From: Stephen Gee [REDACTED]
Sent: 26 May 2021 12:11
To: Michael Eastham <Michael.Eastham@arun.gov.uk>
Cc: Ian Gledhill [REDACTED]
Subject: RE: Water Lane, Angmering - Sales Cabin - BUS STOP RE-LOCATION

Further to our telephone conversation yesterday regarding the re-location of the bus stop on Weavers Hill, please see the email and the plan below from Sean Havis at BDW.

Please could you confirm that there is sufficient space along the site frontage to accommodate the re-located bus stop without the need to take down the flint wall?

Project  
**Land at Water Lane,  
Angmering, West Sussex.**  
Drawing Title  
**Sales Area Layout**

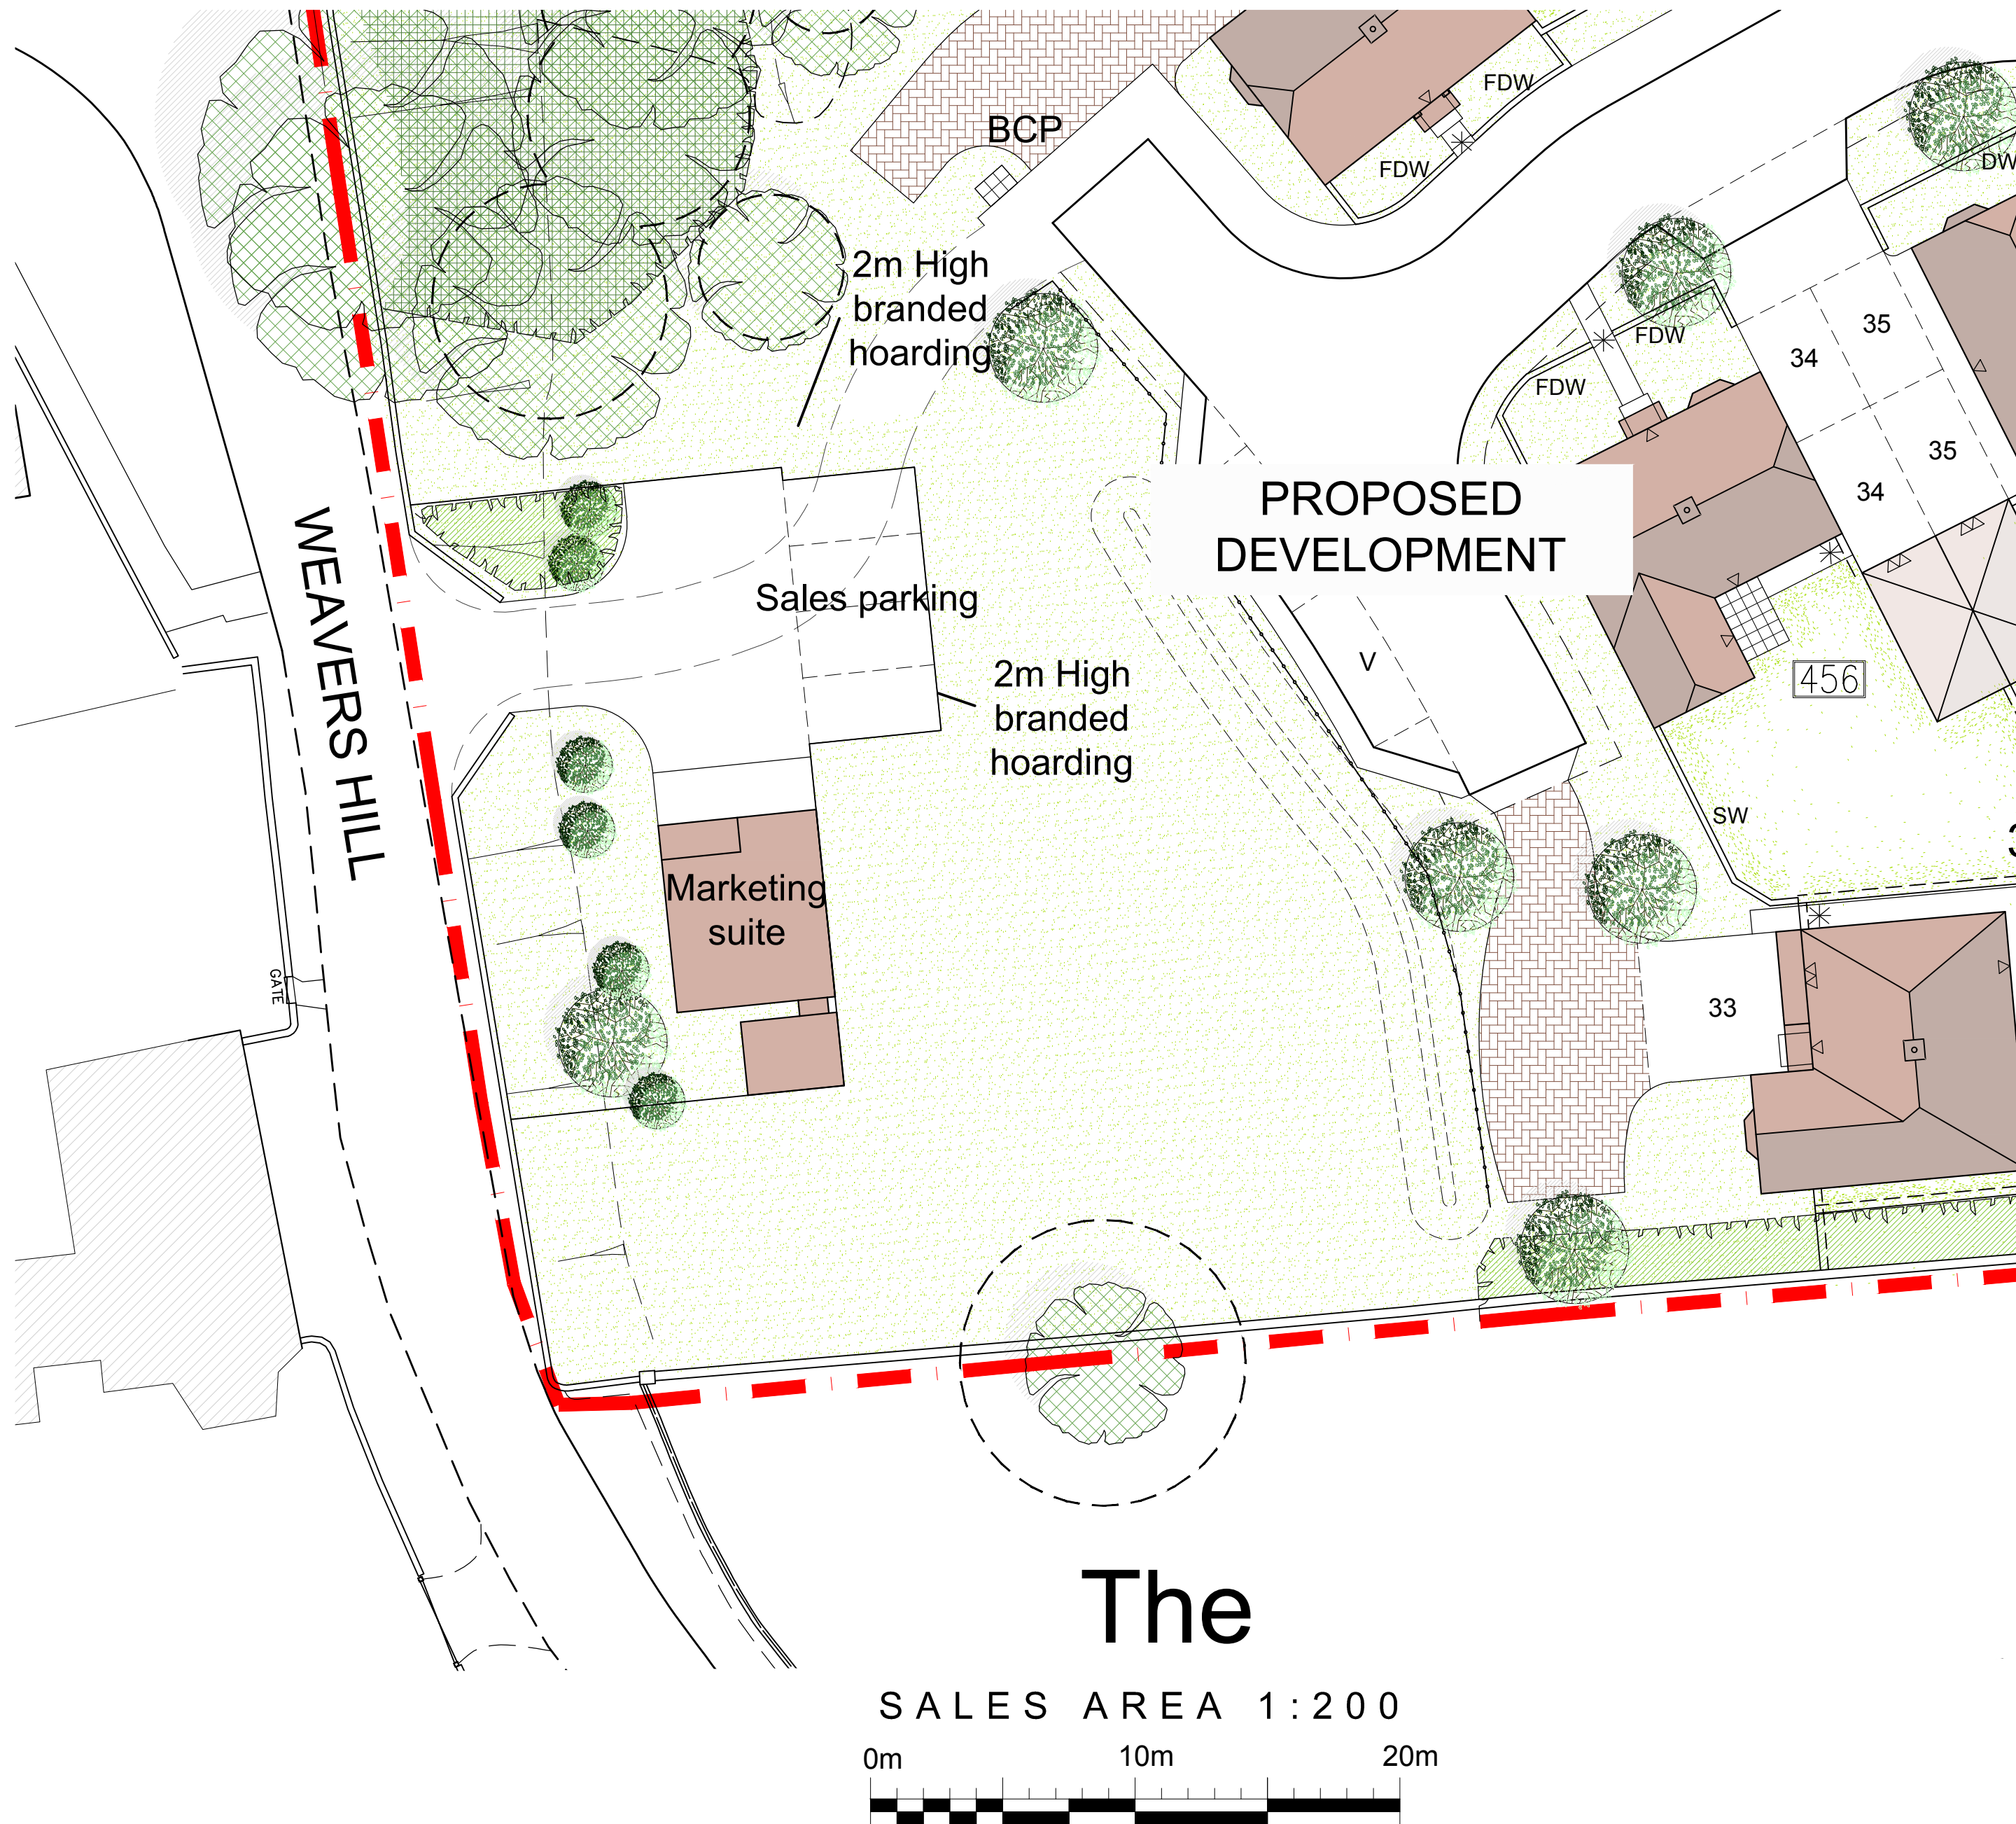
I've just done a quick measurement and according to our plans, those highway works will not affect the flint wall as there is more than 1m room between the highway boundary and the flint wall. I hope this means we can avoid having to change any plans and delay the application further.

Michael,
From considering the two extracts provided below which show a minimum of 1.18m clearance between the wall and edge of footway and the outline permission for A/99/17 which requires a 1m hardstanding I can confirm that the proposals would not result in abortive works to the wall.
